AN COIMISIÚN PLEANÁLA

ACP- 323969-25

Addendum C

Chronology

PROJECT:
House at Strandhill
DRAWING TITLE:
Proposed Roof Plan
STAGE:
Retention Application
DATE:
25/09/2020

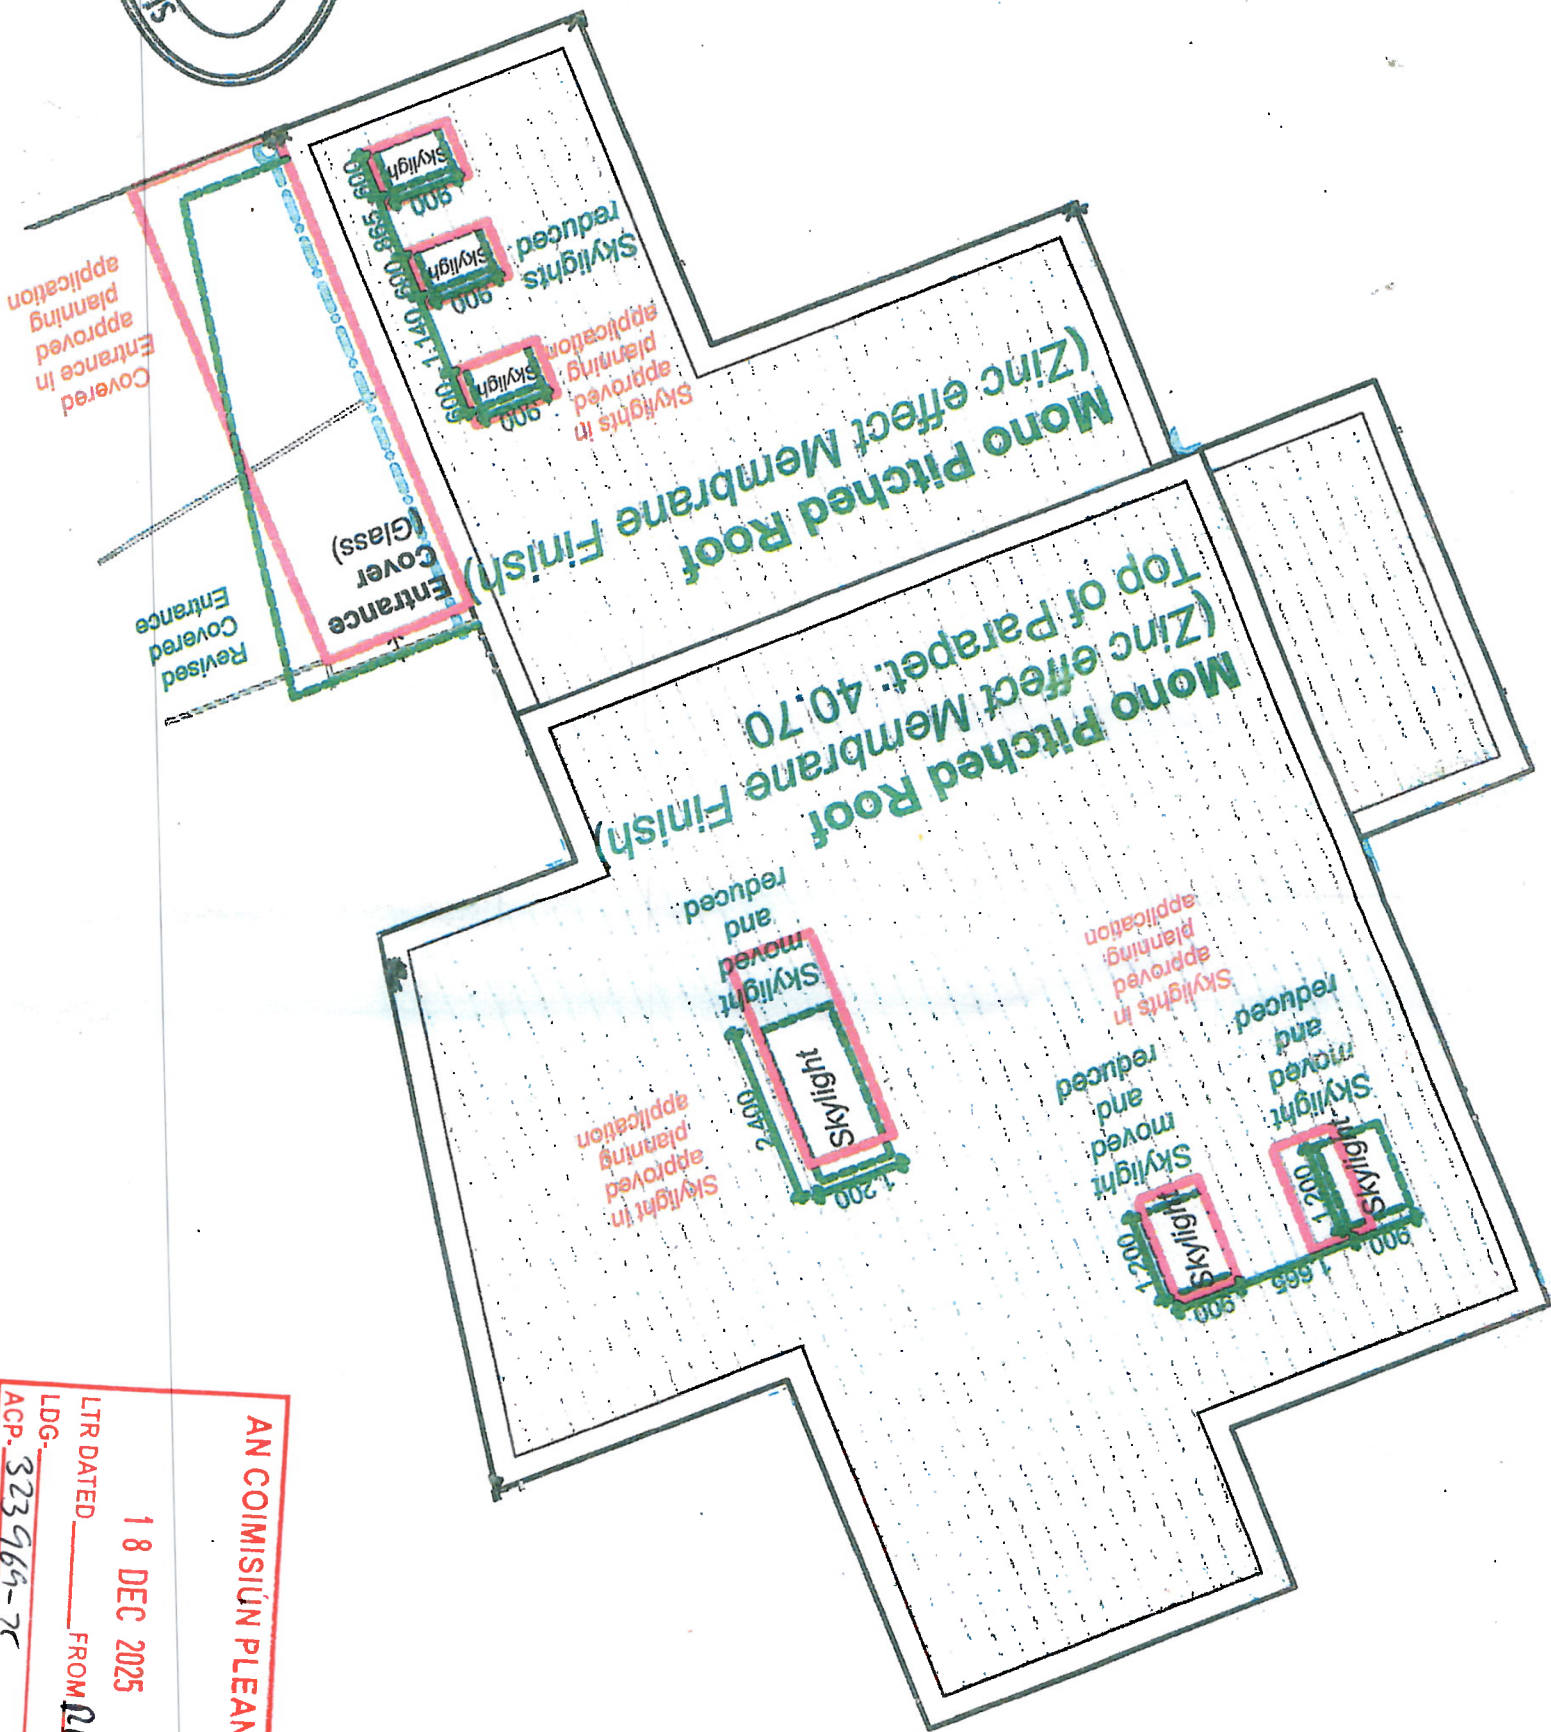
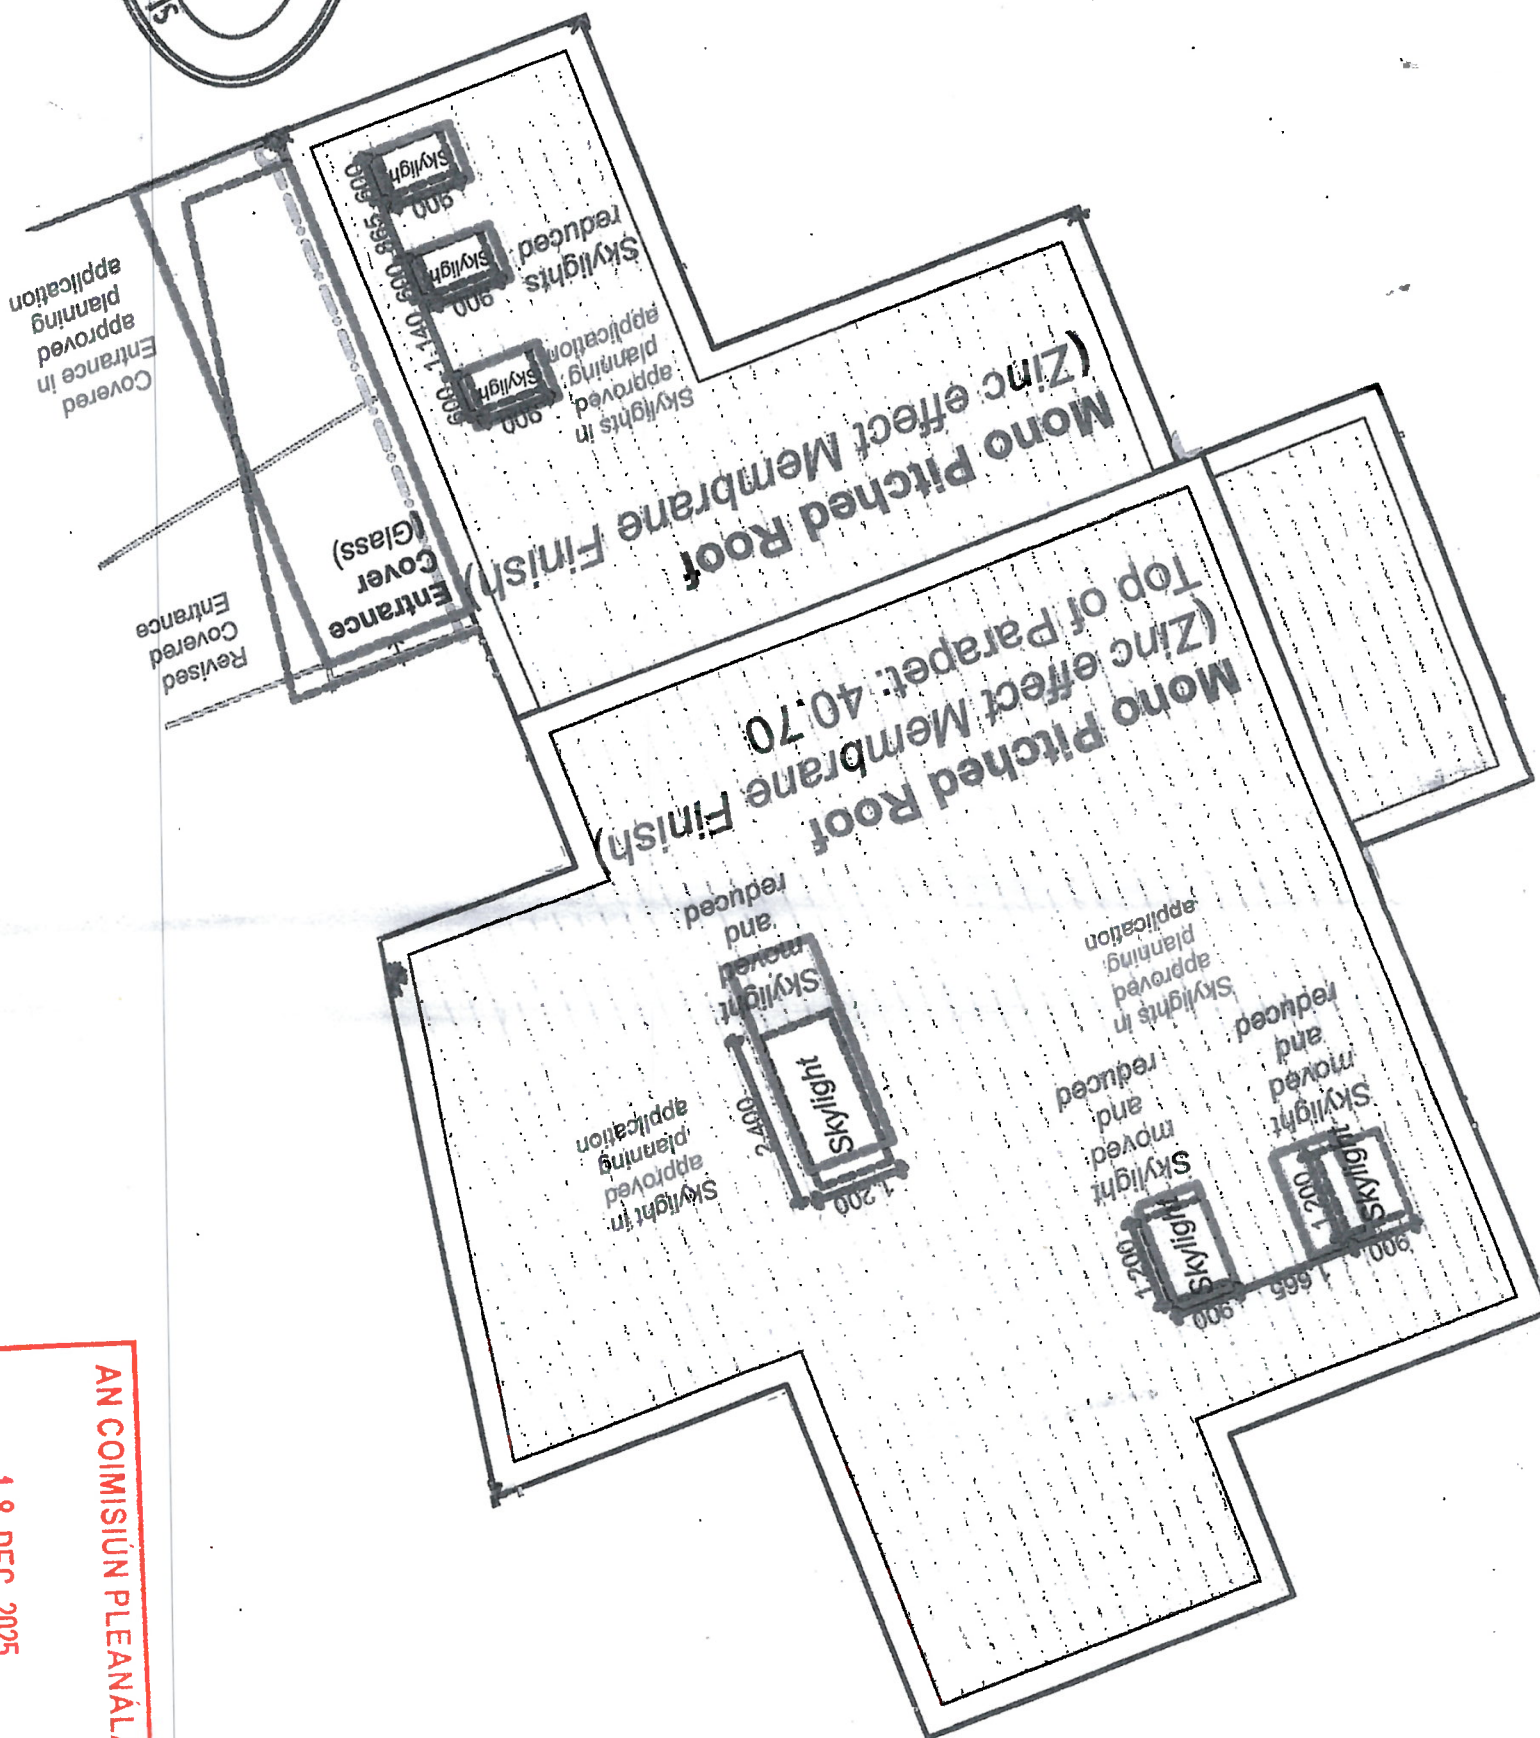
I object to the changes of rooflight dimensions and positions. The Planner's Report for the grant for permission for this development refers to drawing number 1719 -02. This is the architectural drawing with all requisite drawings for the planner's assessment. These drawings do not have any rooflights on the upper level. Therefore, no roof lights have been included in permission.

The upstands of the rooflights extend conspicuously above the parapet as does the flue which is installed (and not included in the grant for retention). The new architectural drawings 1719 R301 mis state the dimensions of these rooflights, the largest listed at 25mm above the parapet. These additions extend the ridge height significantly above the eaves of the neighbouring houses which contravenes permission and shows a complete disregard for the community. This was a very contentious issue explored at length in the previous associated planning application 18365 for this site.
